**From:** Matthew McCann  
**Sent:** 16 April 2021 14:34  
**To:** Clare Howe  
**Cc:** Durk Reyner; Kirsten Roberts  
**Subject:** 6/2020/3420/MAJ

I just got a reminder that the response for Biopark I put together did not reach you. In terms of the application I had selected "objection" for the following reasons:

**BROADWATER GARDENS
PARKING PLAN - BASEMENT 02**

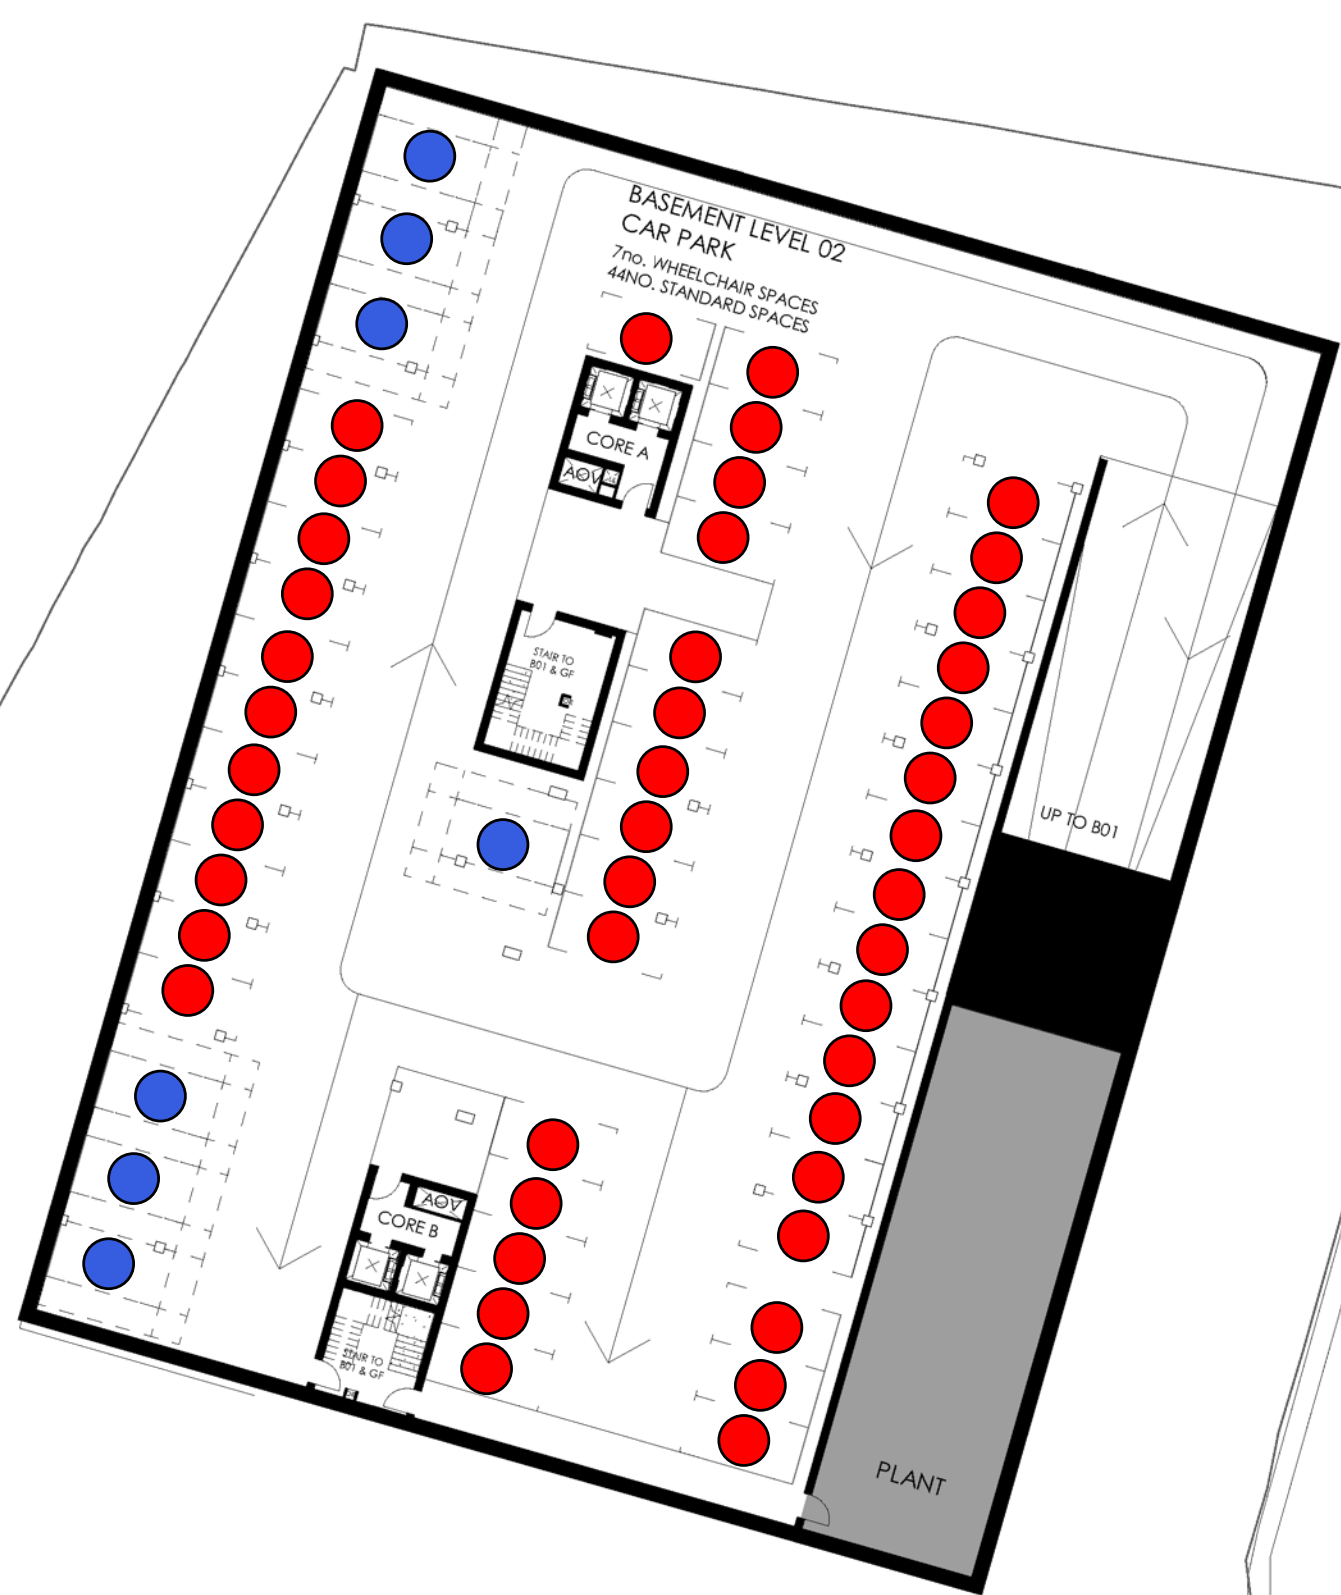
The fob system mentioned in the basement does serve well to manage the parking on the site, but would lead to the strong possibility of residents who may already be in situ purchasing a vehicle and then displacing parking into nearby residential roads which is already subject to parking issues. The 22 visitor spaces is less than 8% of all on site properties, and there would be many times where a family event such as birthdays/Christmas/other religious festivals will increase visitor parking demand beyond this provision. This does also not take into account any regular visitors who may need to come each day to help support a resident and could lead to residents feeling they cannot have visitors come to them leading to additional social isolation. The proposals does not highlight clearly to what happens when there is either more than 22 visitors, or if it's a visitor to see a resident who is not allowed a fob (proposals read the fobs will be issued on first come first served basis to ensure only those with a fob can have a guaranteed and numbered space)
